Our ref: OUT25/8551

Subject: Kurnell Refinery Conversion MOD 7 (SSD-5544-Mod-7) - Modification Report

Detailed advice to DPHI Planning & Assessment regarding the Kurnell Refinery Conversion MOD 7 (SSD-5544-Mod-7) - Modification Report

**Figure 3-1 Acid sulfate soils**

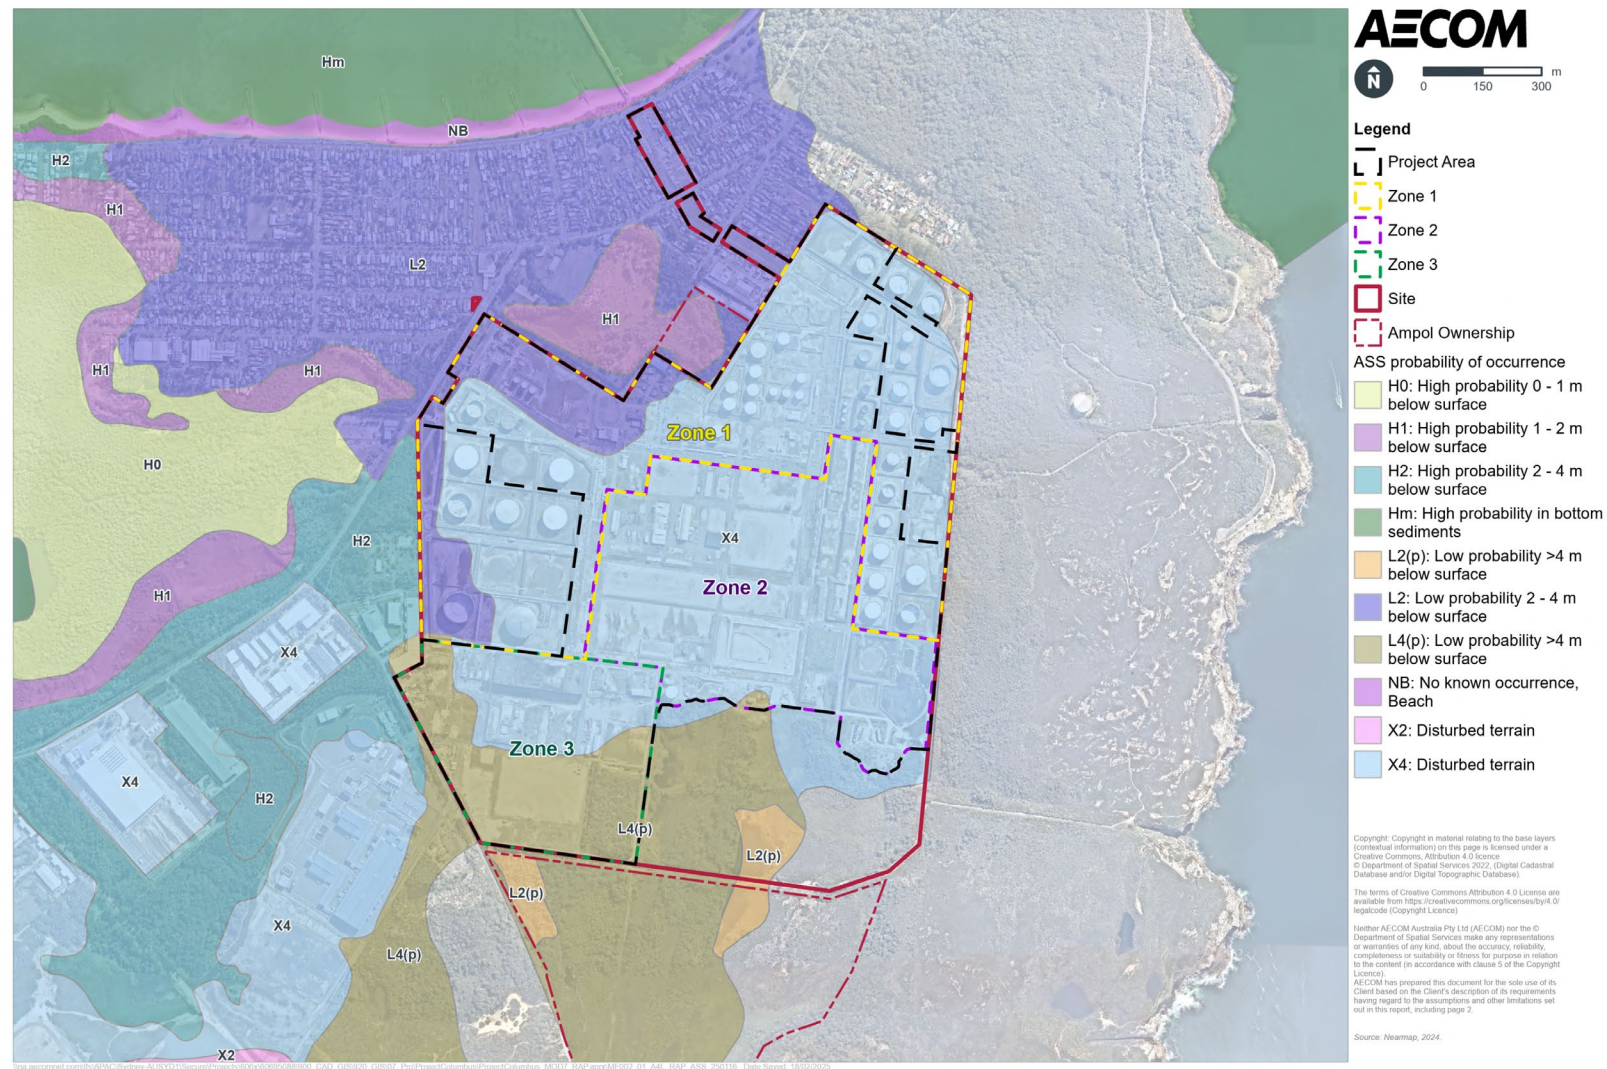
Additionally, potential acid sulfate soils (PASS) have been identified at depths greater than 2 m below ground level (mbgl) in parts of the site. Page 73 notes the potential for >1,000 tonnes of PASS to be excavated. Water from PASS dewatering will be treated via the WWTP under EPL conditions. No further information is provided regarding water quality management for PASS. Other key contaminants of potential concern (COPC) within the Project Area include, petroleum hydrocarbons (PHC), per- and polyfluoroalkyl substances (PFAS), and Asbestos in soil. Without a defined extraction volume, and with only limited information, it is unclear whether the WWTP has sufficient capacity to manage the dewatering load and process that defines whether the groundwater is unsuitable for on-site treatment, or when it will be transported to a licenced offsite waste facility.
